From: Fiona Fitzgerald
Sent: 24 July 2017 11:52
To: Richard Temple
Subject: FW: Planning Consultation on: BR/199/17/PD

APPLICATION BR/199/17/PD

Site Address: 5-7 Station Road Bognor Regis PO21 1QB

Description of Works: Application for prior notification under Class C for change of use from Shop (A1) to Restaurant (A3)

068_P_04

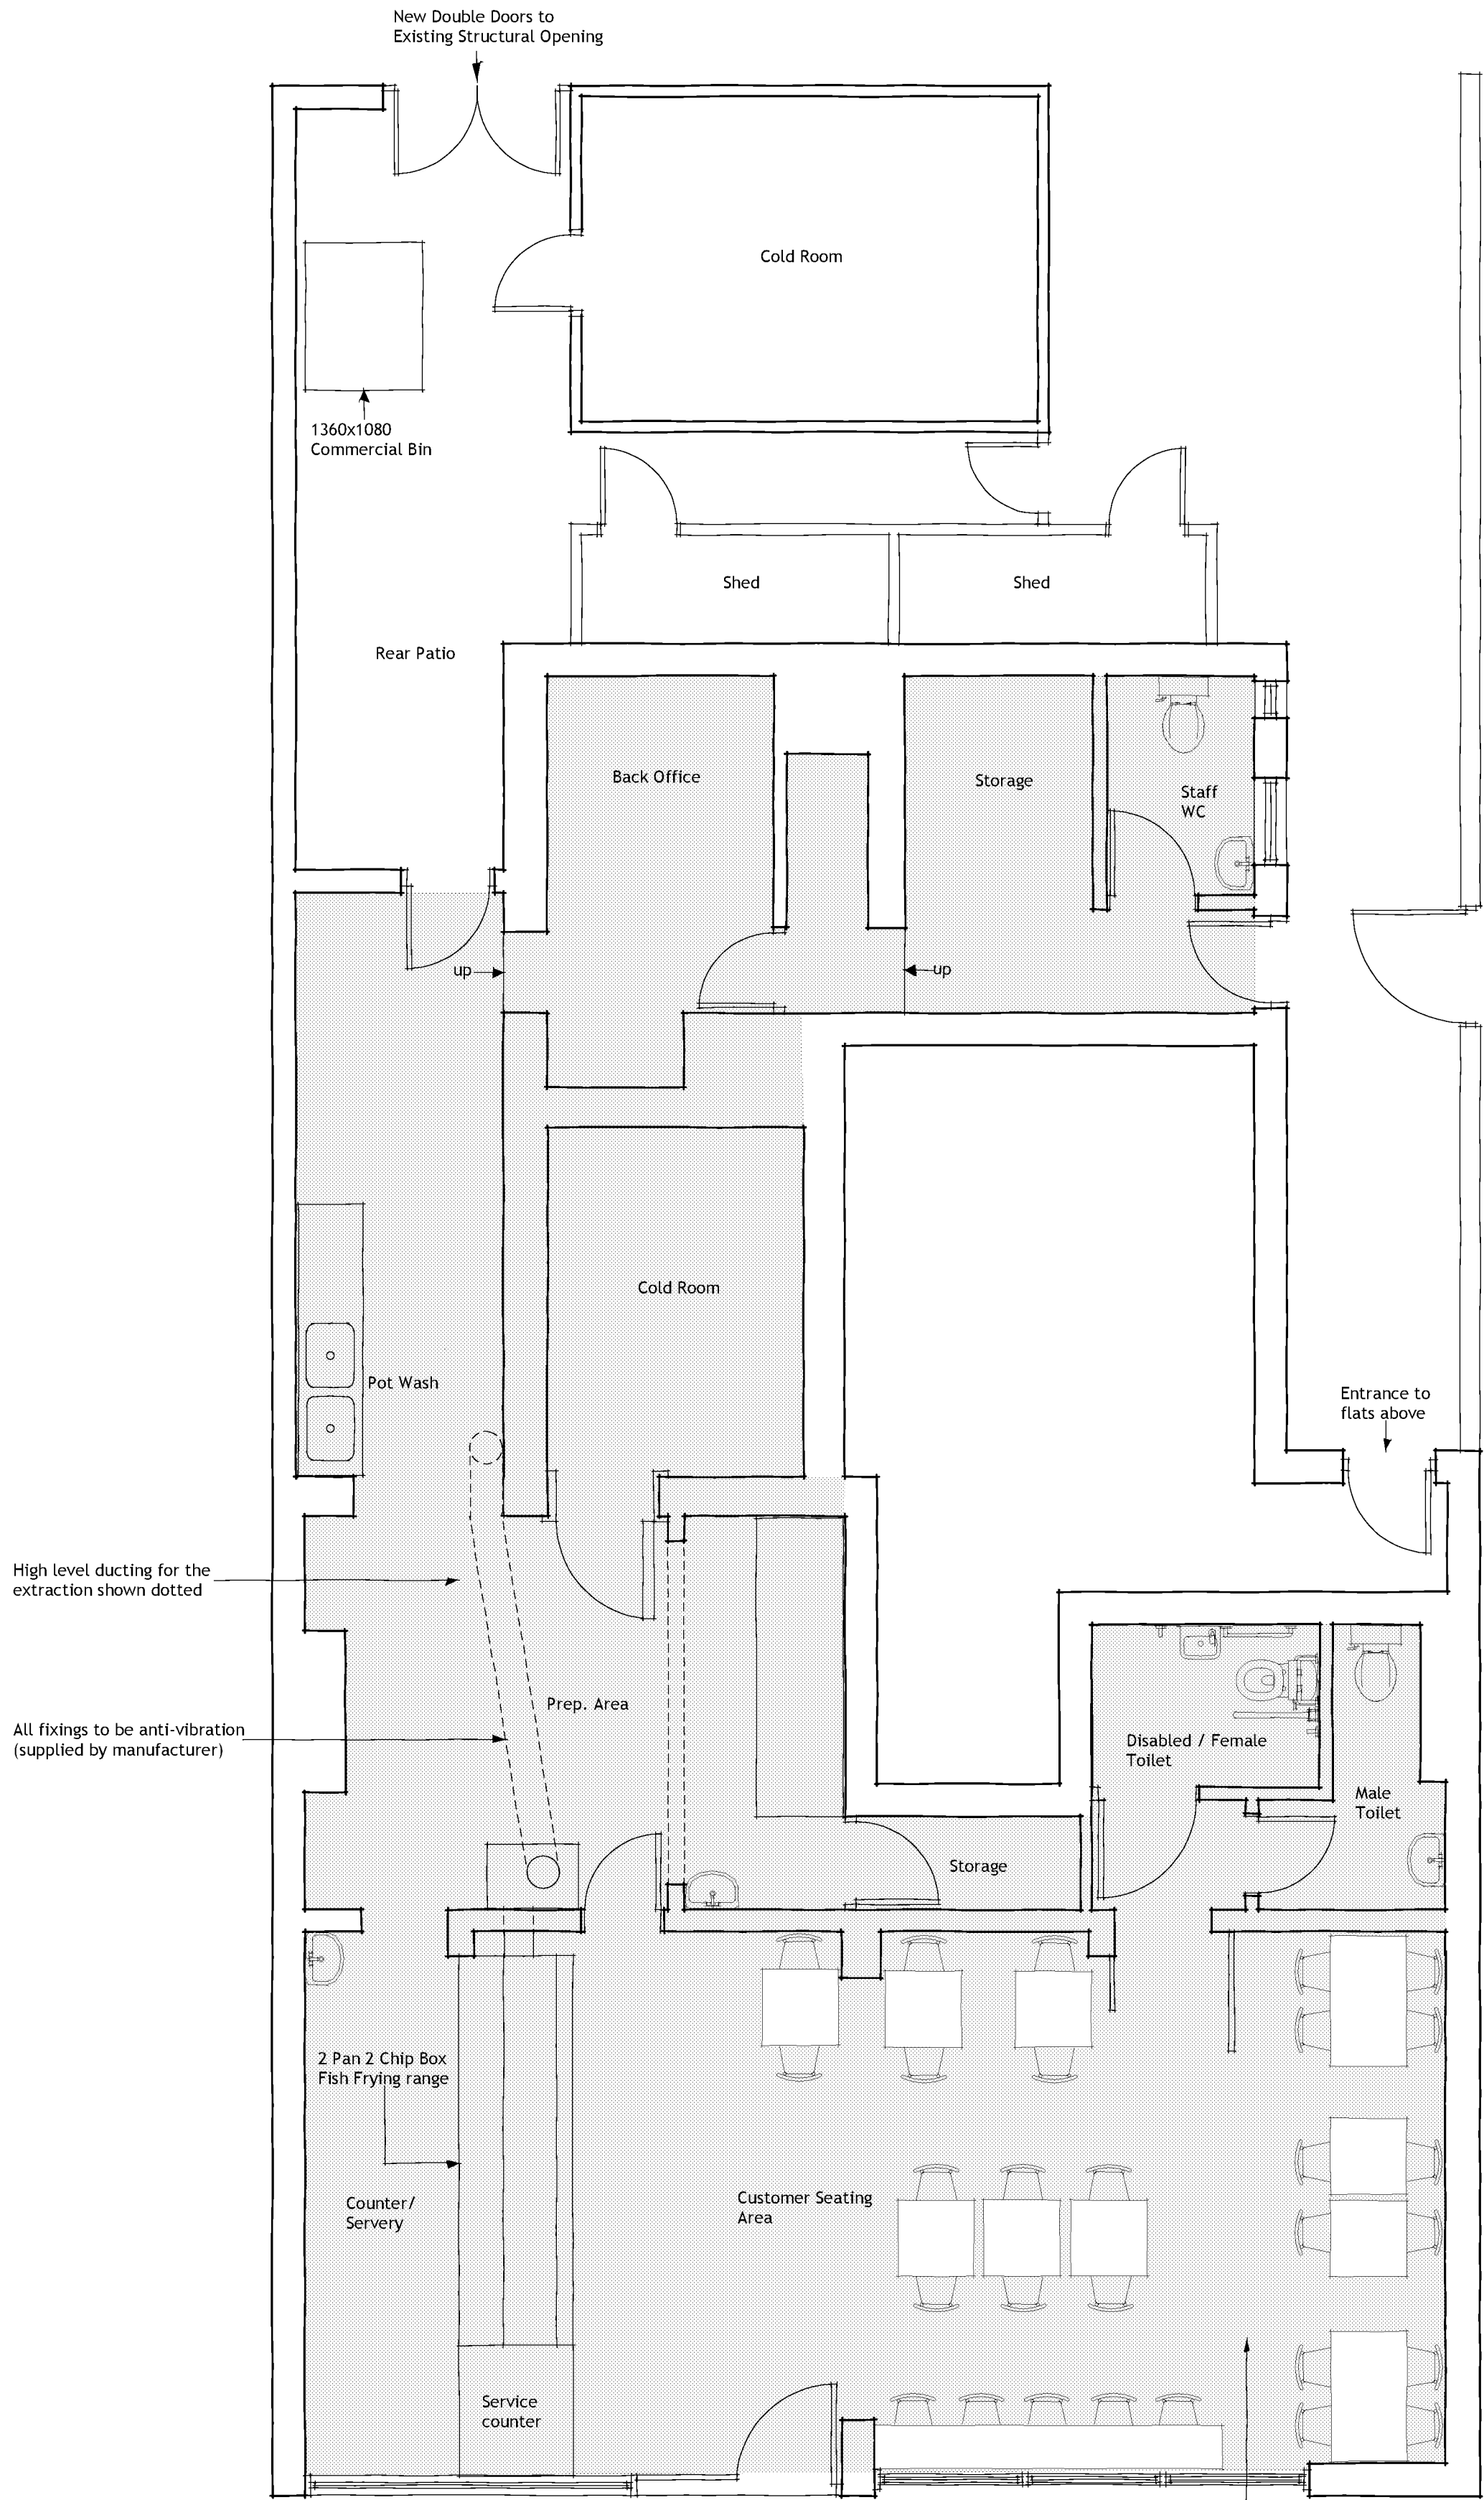
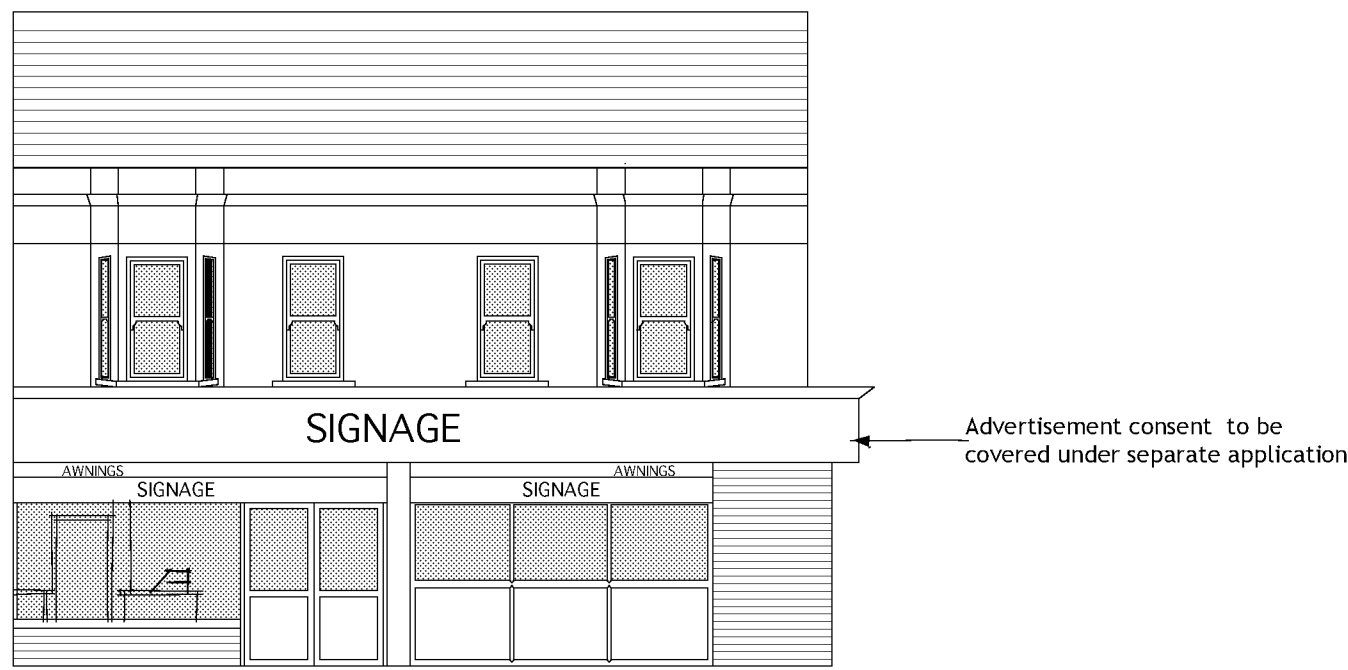
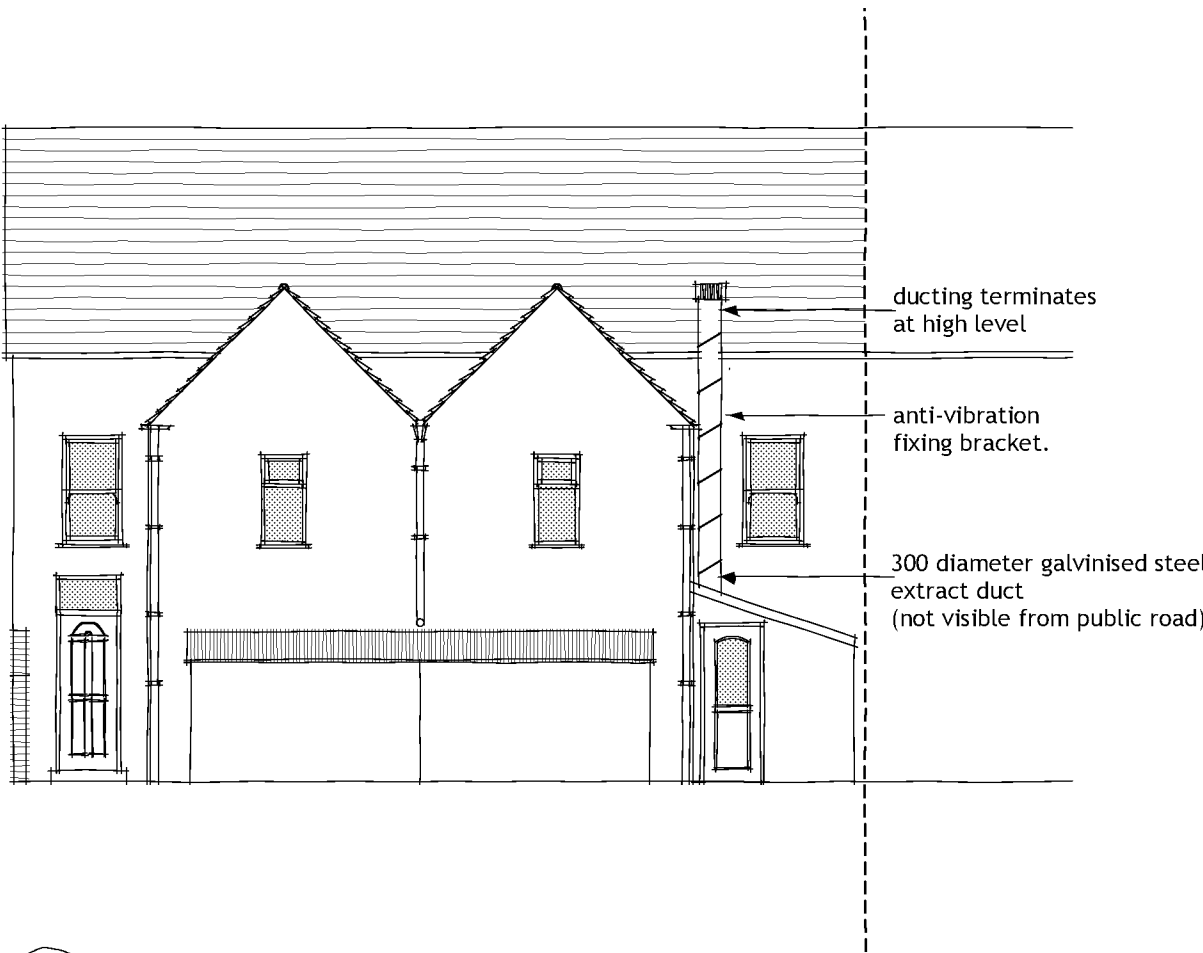
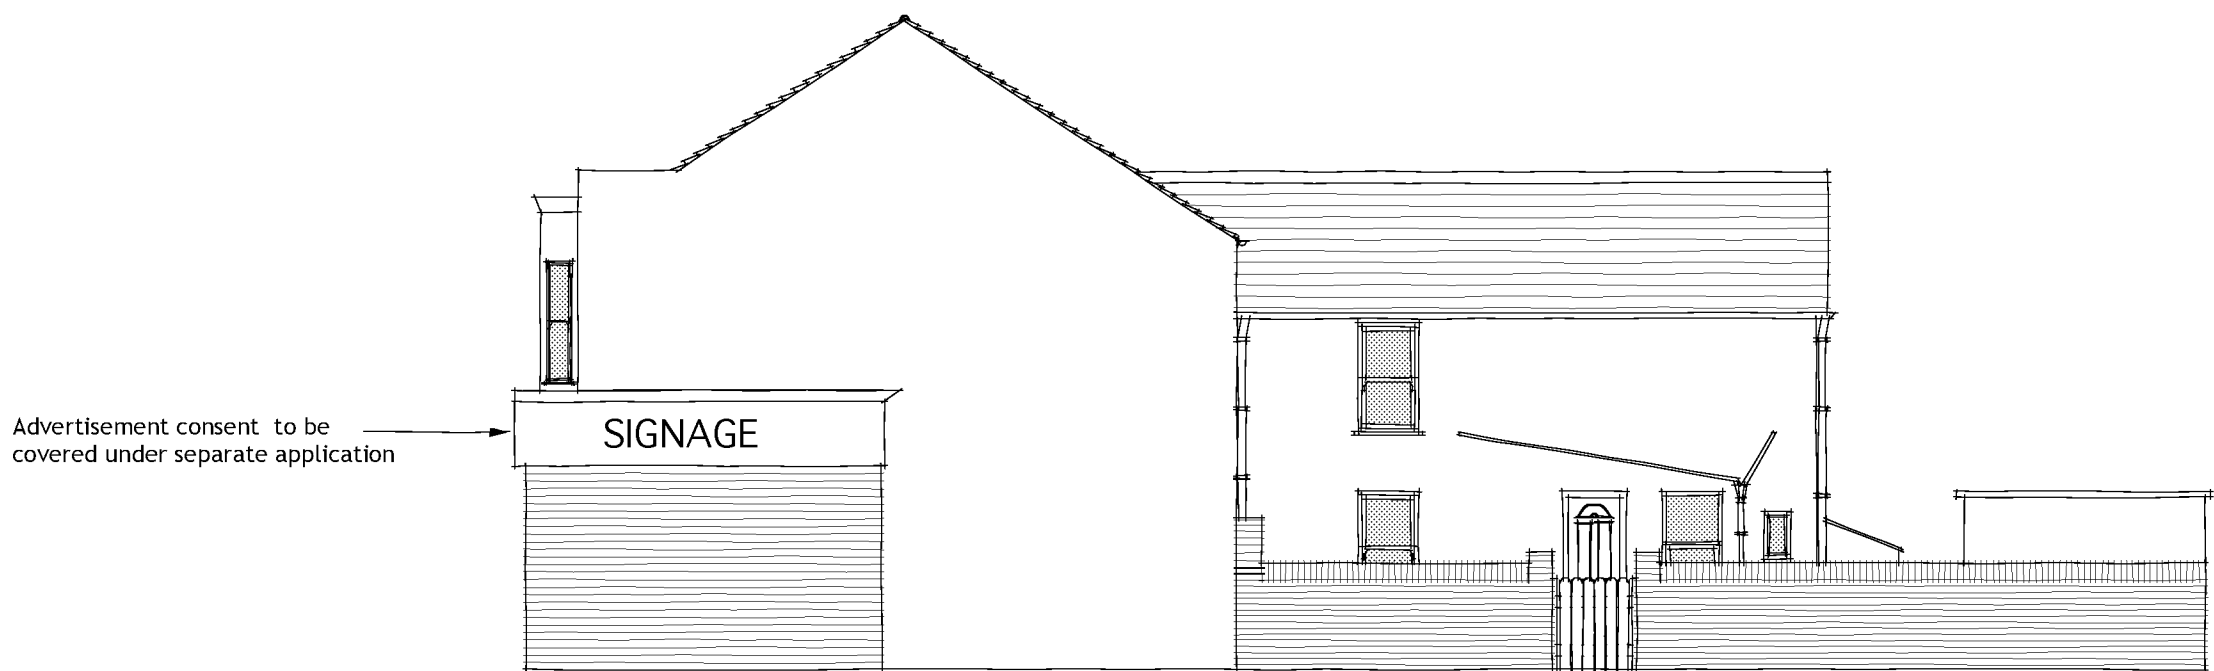
I have no objections to this in principle. However I note that it looks likely to be a premises serving Fish and Chips and that the applicant has shown on the plans where the ducting for the kitchen ventilation will be. As there are residential premises above, there is the potential for both noise and odour to affect the residents of the flats. Please could the applicant submit further details to allow assessment of the proposed extraction unit to be carried out. I would direct the applicant to the DEFRA guidance 'Guidance on the Control of Odour and Noise from Commercial Kitchen Extract Systems, January 2005).

Should this information not be forthcoming, Environmental Health would be likely to object on the grounds of insufficient information on noise.
